OBJECTION

State Significant Development Application No: SSD-10300

Coffs Harbour Cultural and Civic Space

GORDON ST ELEVATION
ISSUE

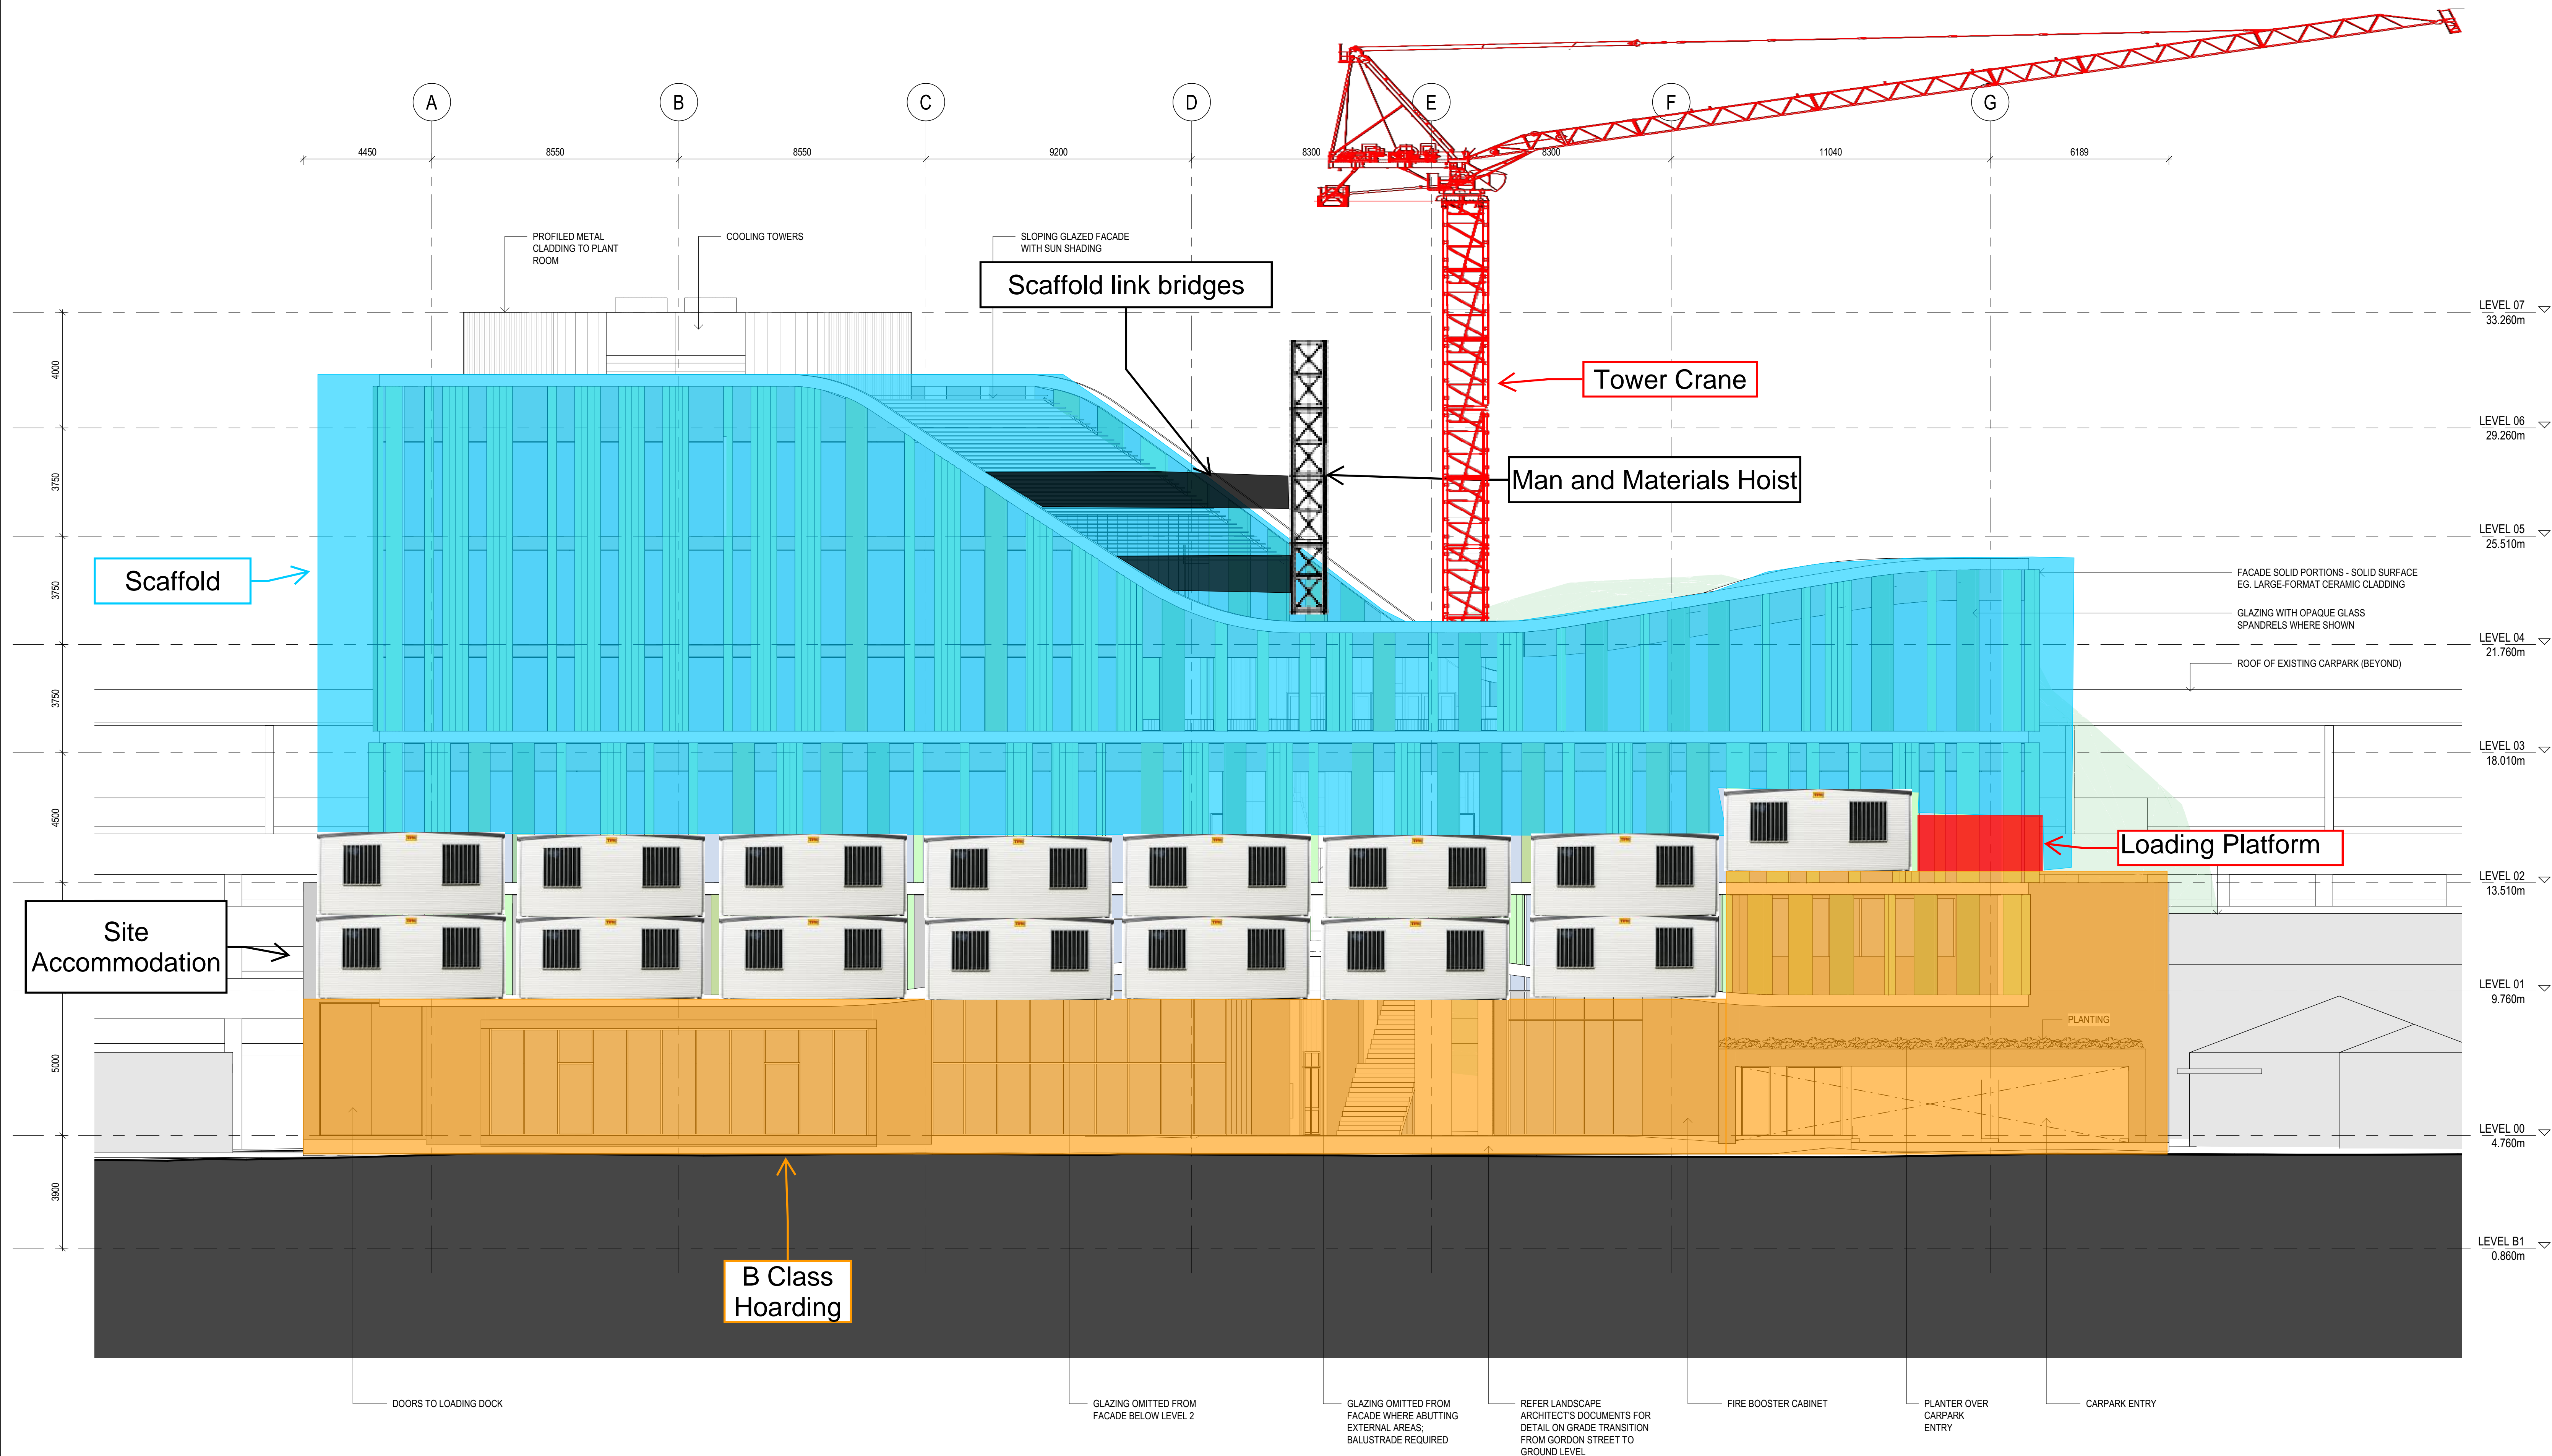
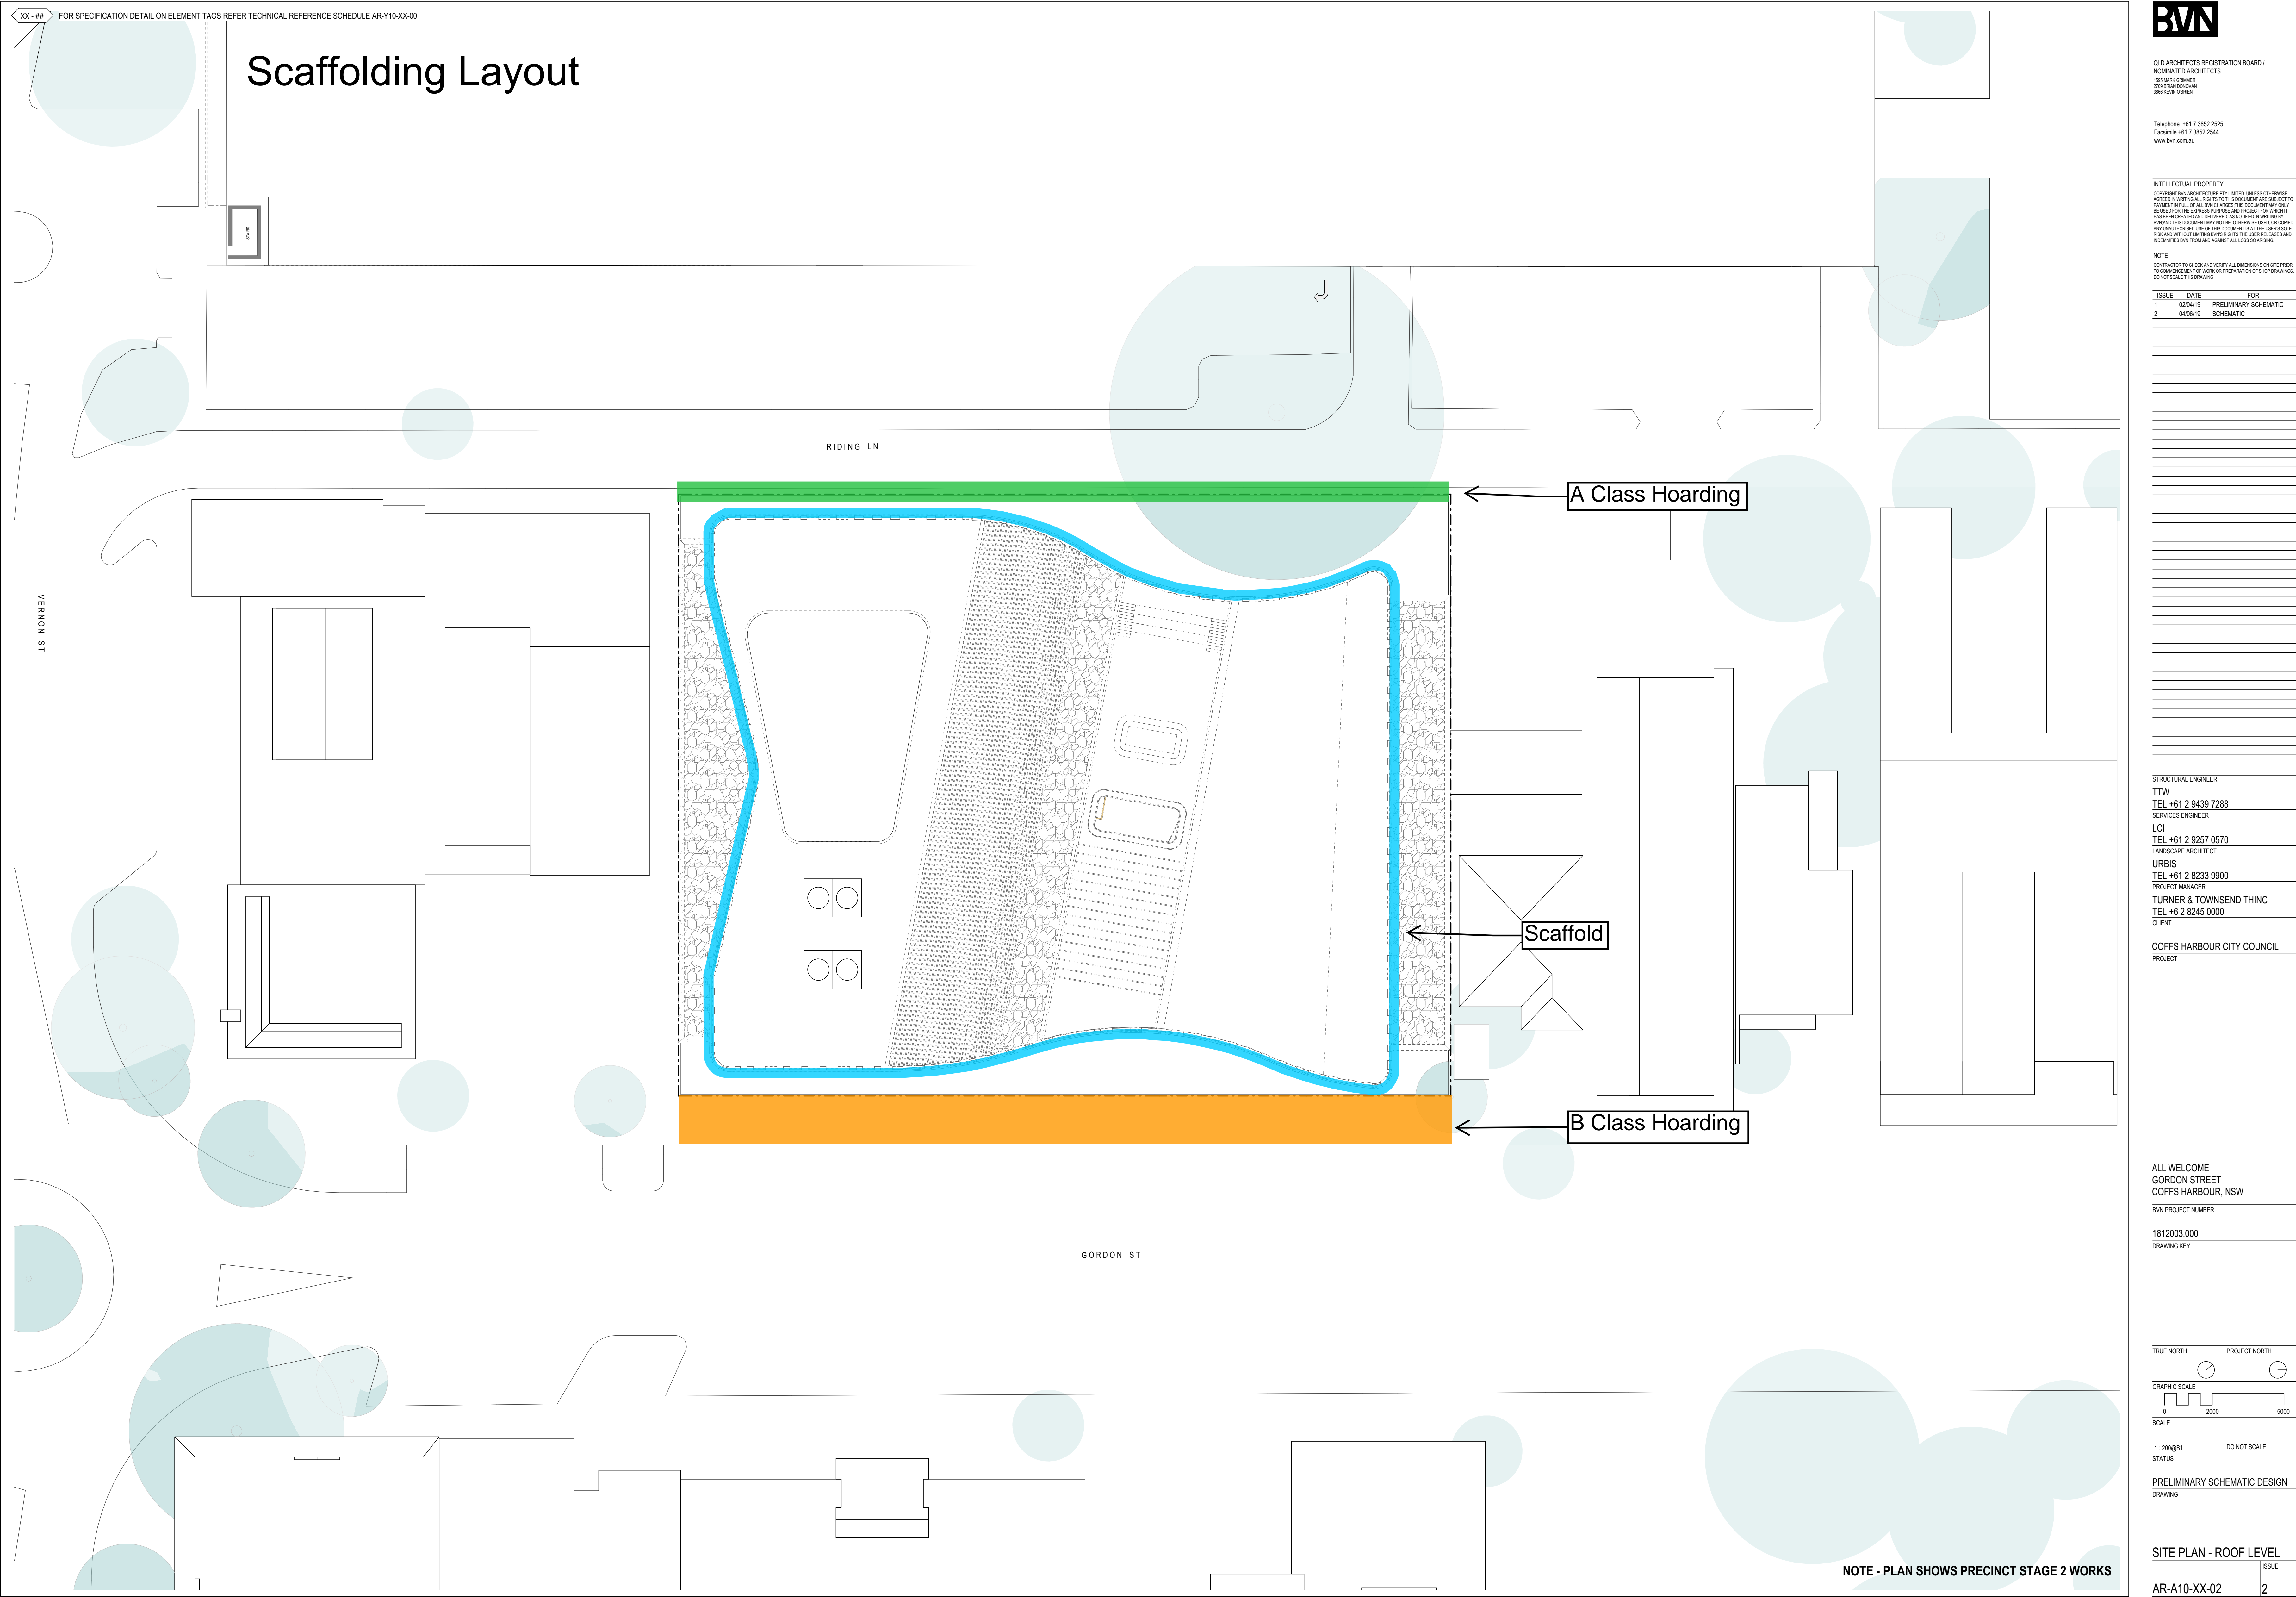
5. The proposed building is out of context in the street with no regard to scale, existing street setbacks, design and general form of adjoining buildings.

7. As a public building it fails to provide sufficient climate protection for pedestrians during storms and summer sun.
8. The building exceeds the height restriction of 28m set down in Council's own planning controls. Council's argument for variation is not satisfactorily justified and is not consistent with the objectives of the Environmental Planning and Assessment Act 1979, which requires the "the orderly and economic use and development of land". Council should not receive preferential treatment.
